Sheet-LA1.1 (page 1 of 6)

1. Provide written documentation from the owner of 5001 E Mercer Way describing the extent and duration of the access.
Written documentation from the owner of 5001 E. Mercer Way has been included with this submittal, see Authorization letters.
2. Where are erosion control measures?
Erosion control measures are demonstrated on the Wall Excavation Plan, Sheet LA2.2
3. The hardscape numbers do not match the Site Development Worksheet. Please double check and update and resubmit the plans and Site Development Worksheet as necessary. Please remember that decks count as hardscape.
The site development worksheet has been updated to the current format released by the City of Mercer Island in January of 2020. Changes are reflected on Sheet LA1.1

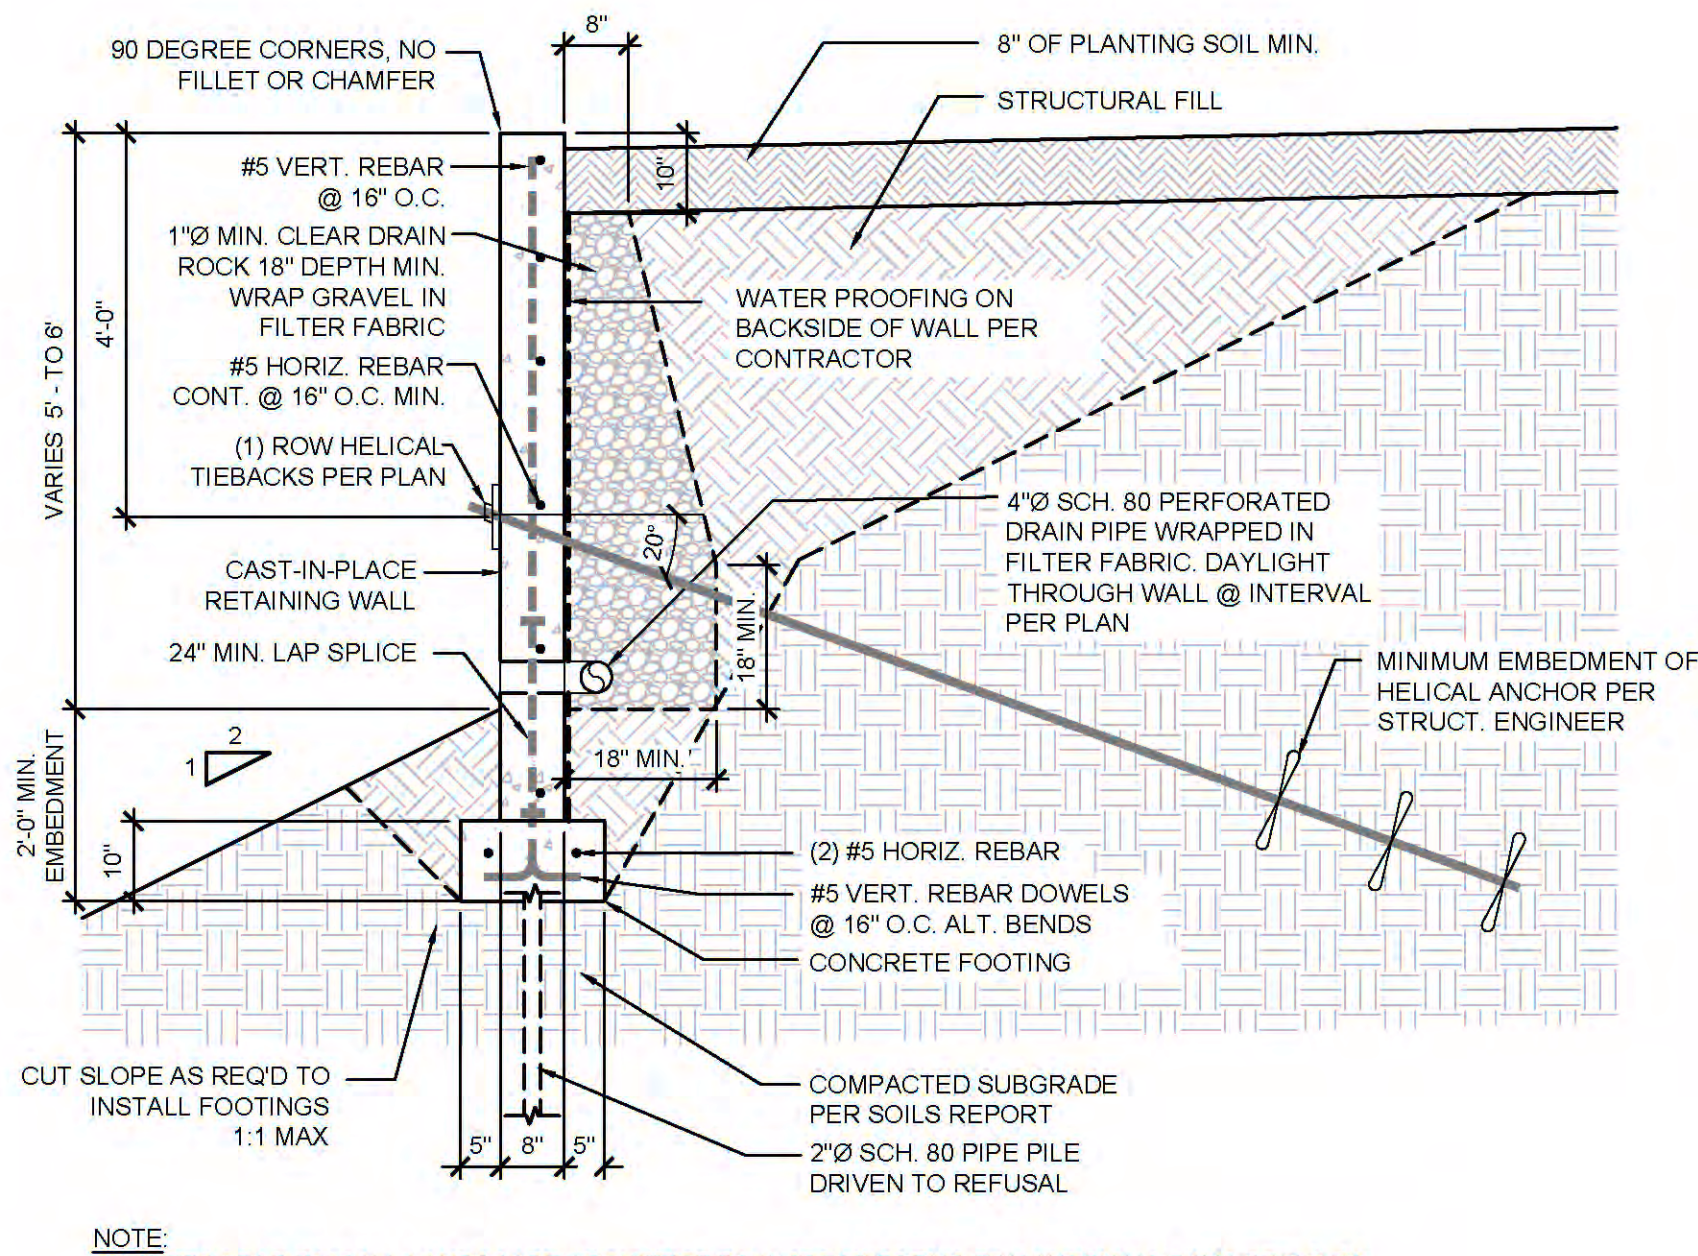
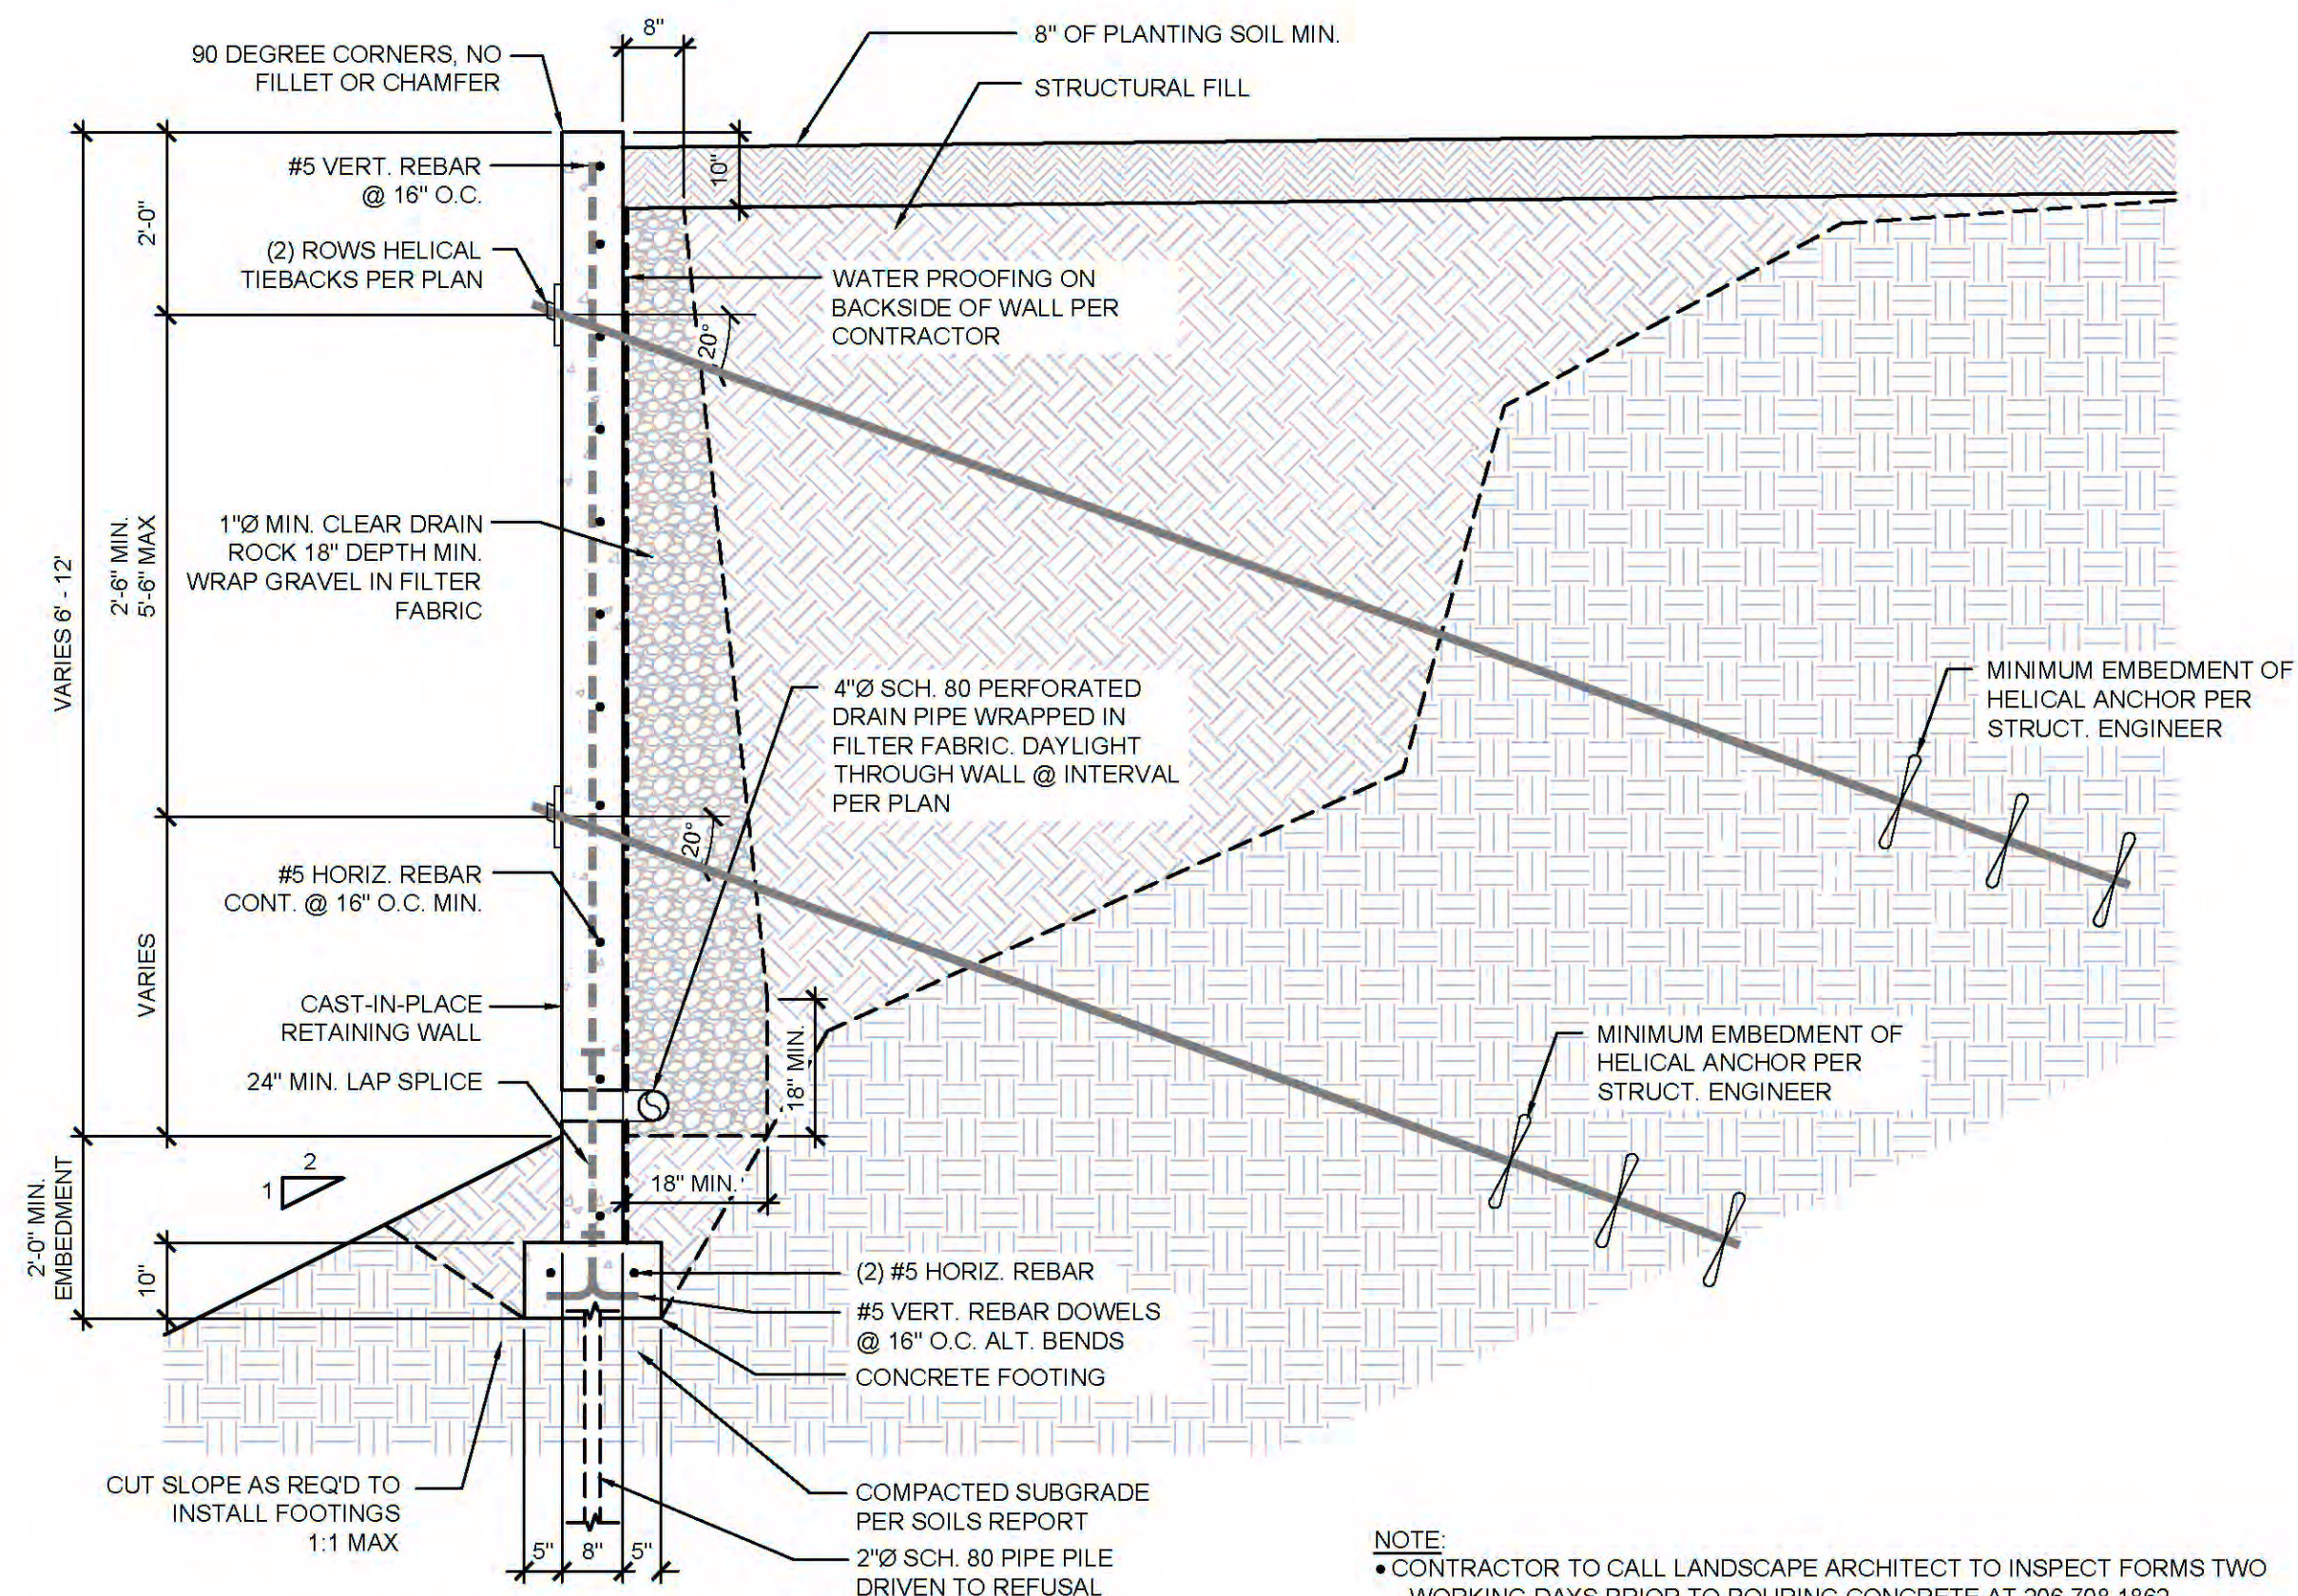
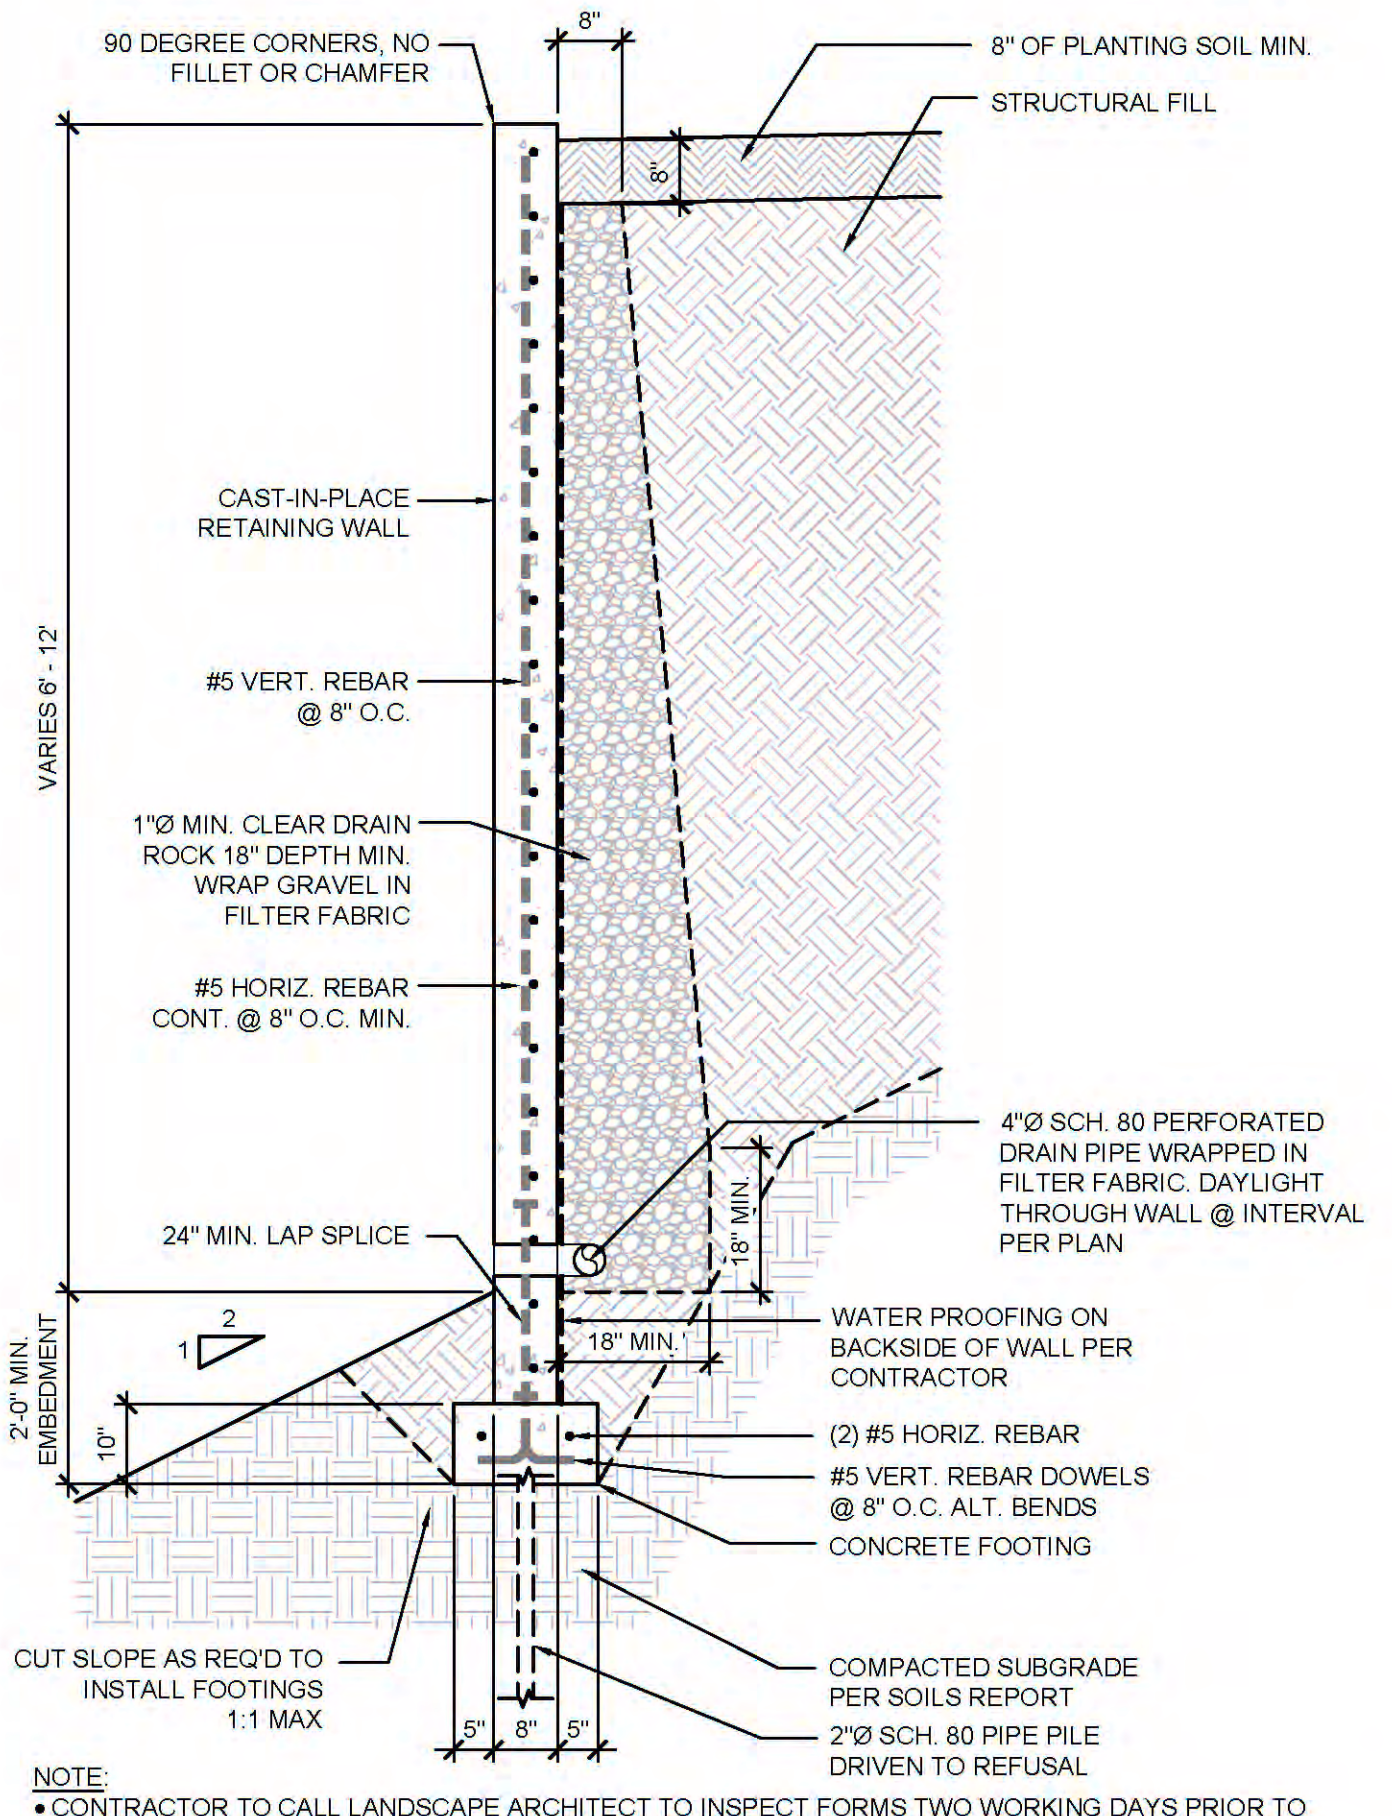
18. The geotechnical report recommends 18-inch width of drainage material along the entire wall height, not 8-inches increasing to 18 inches. Revise all wall sections.
The detail on sheet LA3.2 have been edited to show 18-inch width drainage material along the entire wall height.

19. The proposed drain location does not match the recommendation on plate 3 of the 2019 ESNW Geotech report.
The proposed drain locations have been updated per the 2019 Geotech Report.

20. Wall drainage should not be allowed to exit through wall onto slope in front of wall. Wall drainage should be collected and tight lined to a controlled discharge location (not onto slopes). Revise all wall sections.
Drainage for the wall will be collected by footing drain and tight lined to the nearest storm catch basin.
Please see Wall Drain Plan and Details on Sheets LA2.3 - LA2.5

21. An excavation plan will be required to reflect the temporary excavation necessary for installation. The geotechnical report 2/5/19 recommends a cut of 1.5H:1V on page 2, these details note a maximum of 1:1, and the detail graphically depicts a cut much steeper than this. Please coordinate between all disciplines to correctly reflect the cuts necessary for construction.
Please see the Wall Excavation Plan on sheet LA2.2. Details have been edited to reflect a 1.5H:1V max cut.

23. Provide a detail of the footing reinforcement through a typical step, and a max step height "x"
The allowable vertical step and step reinforcing has been added to detail 4 on sheet LA3.2.
